KITTITAS COUNTY COMMUNITY DEVELOPMENT SERVICES

June 16, 2014

Subject: Final Planned Unit Development Application for the Ranch on Swauk Creek

**RANCH ON SWAUK CREEK - PHASE 1, DIVISION 1 - P.U.D.**  
A PORTION OF THE SOUTHEAST 1/4 OF SECTION 28, T. 20N., R. 17E., W.M.  
KITITAS COUNTY, STATE OF WASHINGTON

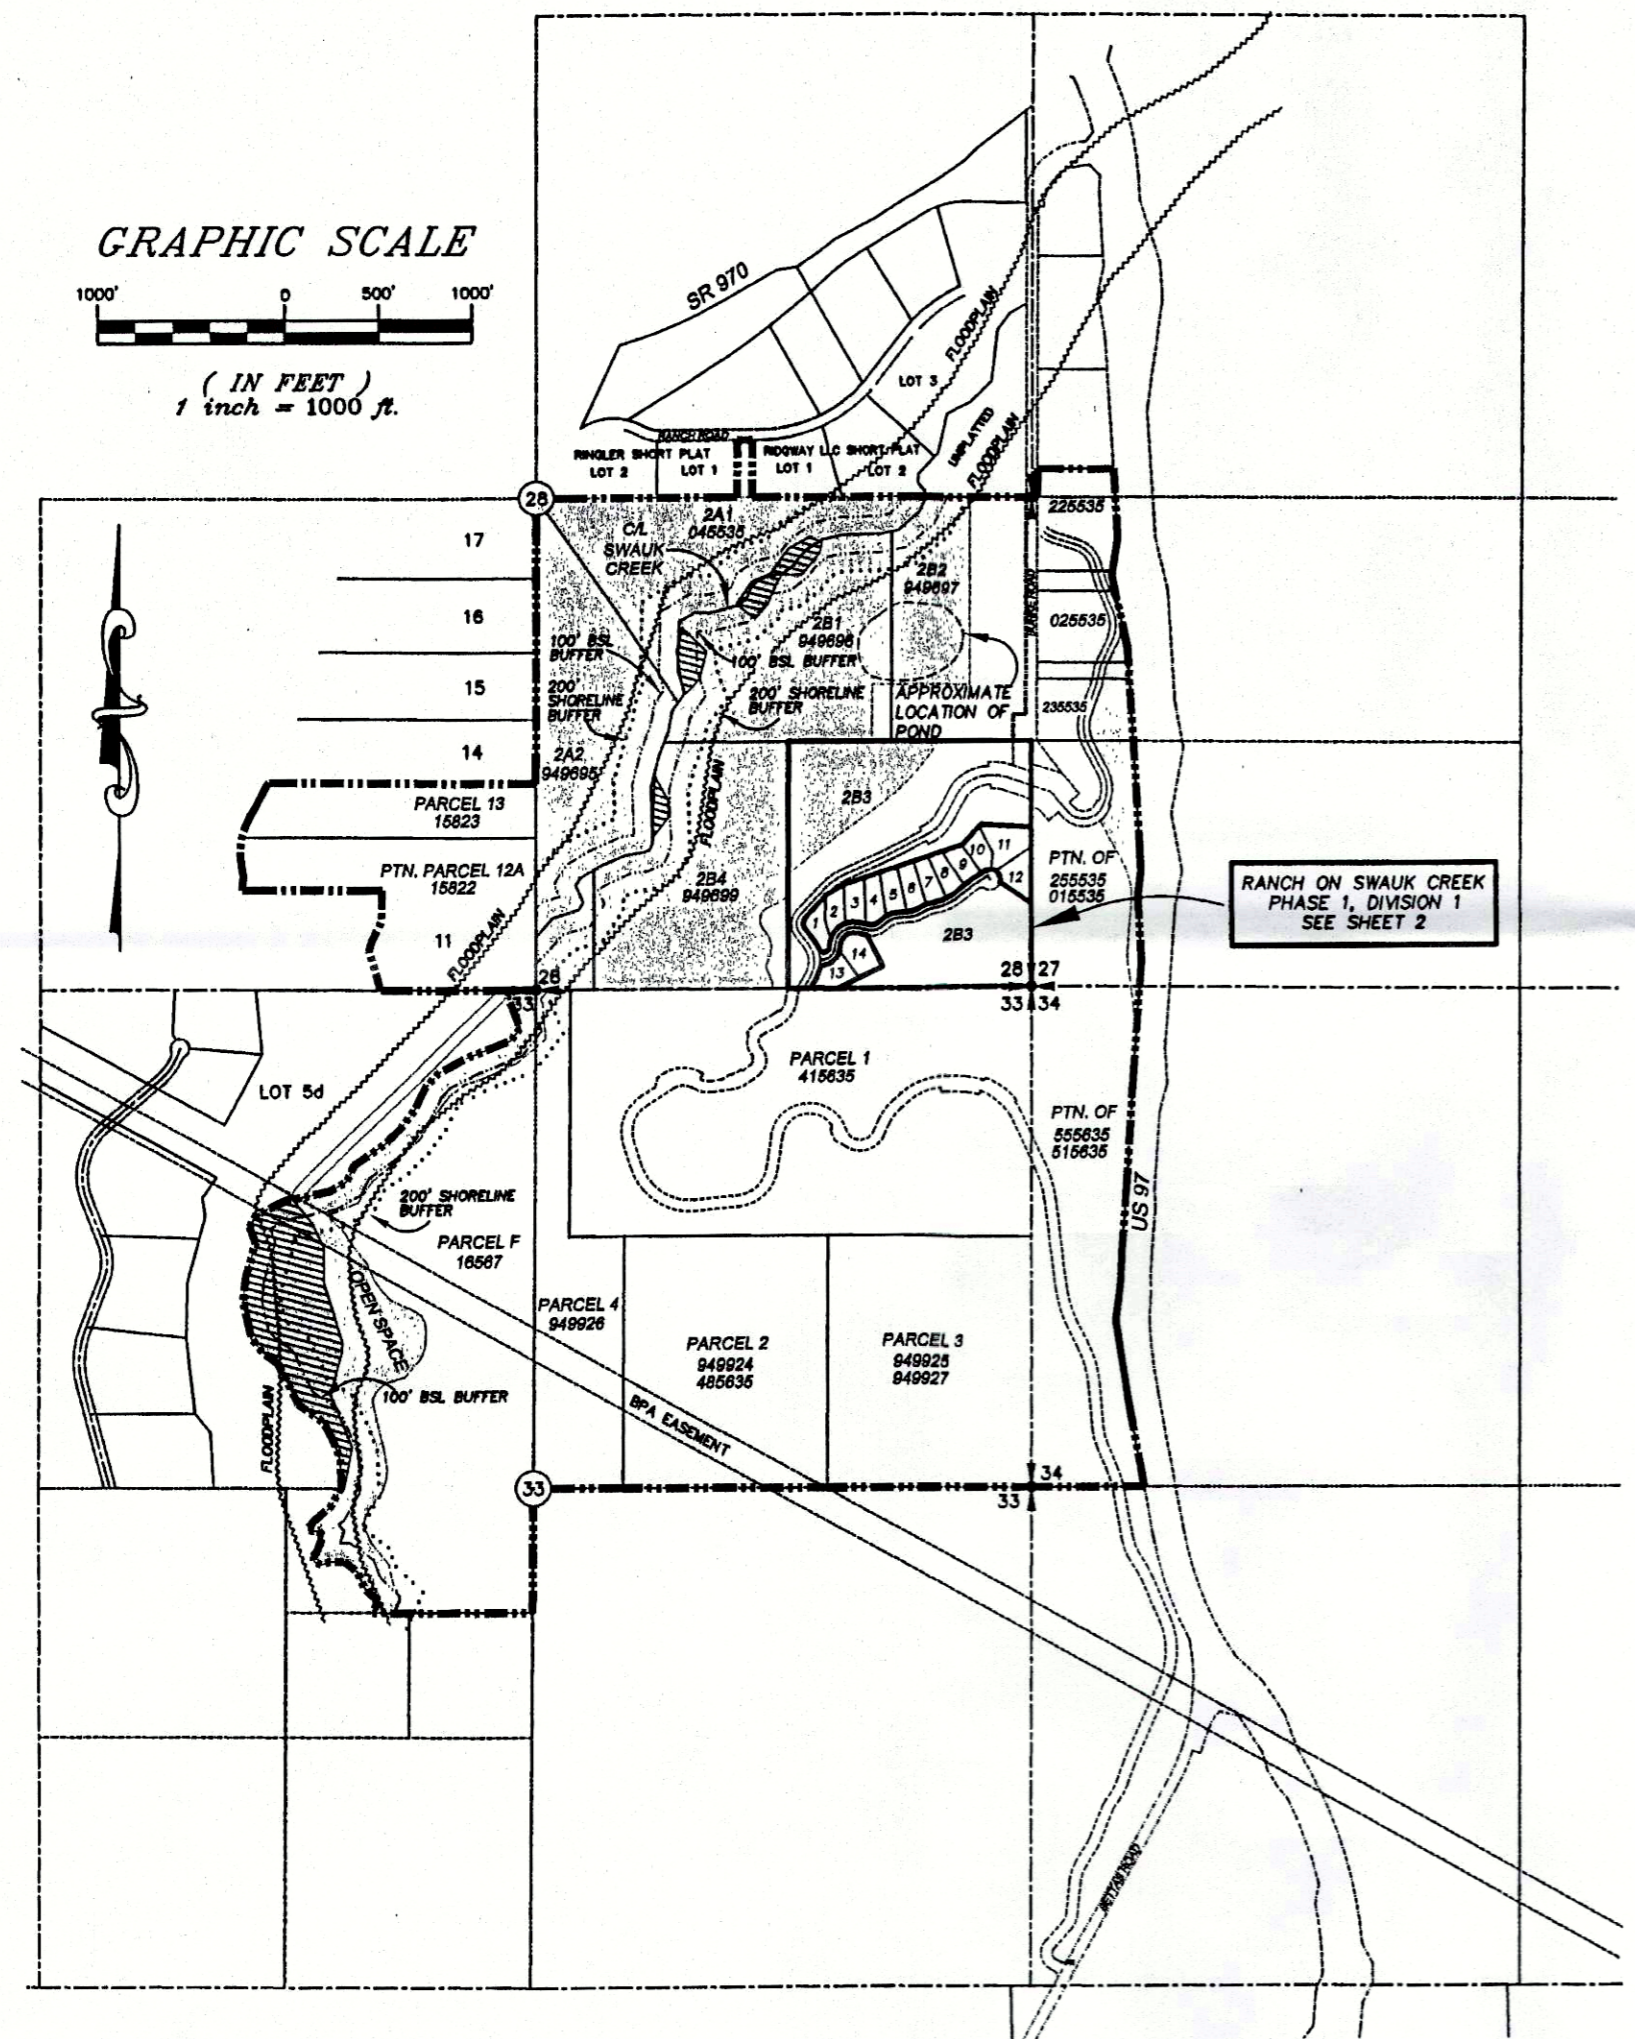
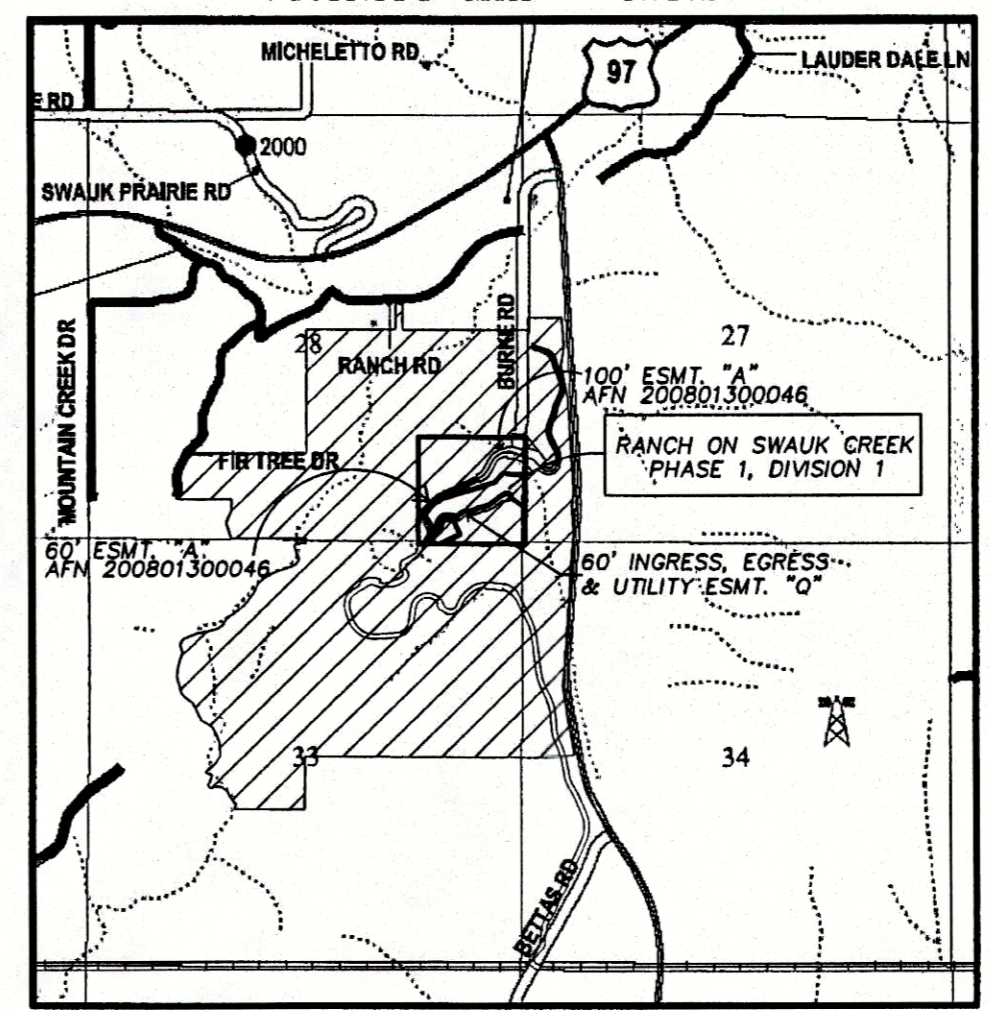
Your application reference table indicates the sequence plan is attached at C. Our review of Attachment C finds that it a copy of the Phase 1, Division 1 Subdivision creating 14 lots approved by the County in October, 2008. This plat document doesn't give sequence of construction information for the PUD as a whole, nor does it give complete information for the full build out of Phase 1, only 14 lots are shown, yet the FPUD application is clear that 81 lots are proposed in Phase One and 81 more lots each in Phases Two and Three.

There is not a comprehensive map showing either, all 81 lots in Phase 1 or all 243 lots proposed for Phases 1-3. A schematic map meeting the scale requirements needs to be provided so that it is clear what is being approved. Attachment C is referenced in your application but this addresses only the Phase 1, Division 1 Subdivision.

Attachments B and C depict the range of building types proposed but only for the 14 lots in Division 1. What is not showing is the proposed buildings for all of Phase 1 (if seeking phased approval) or all of Phases 1-3.

Attachments C and K do show the common open spaces although there does not appear to be an area calculation. These open spaces and calculations need to also be reflected on the main map exhibit.

In order to meet this criteria for Phase 1-3, at a minimum, the staging plan and construction sequence information needs to cover all 243 lots. If the proposal is only for Phase 1, then the staging and construction sequencing narrative needs to cover all 81 lots in Phase 1.
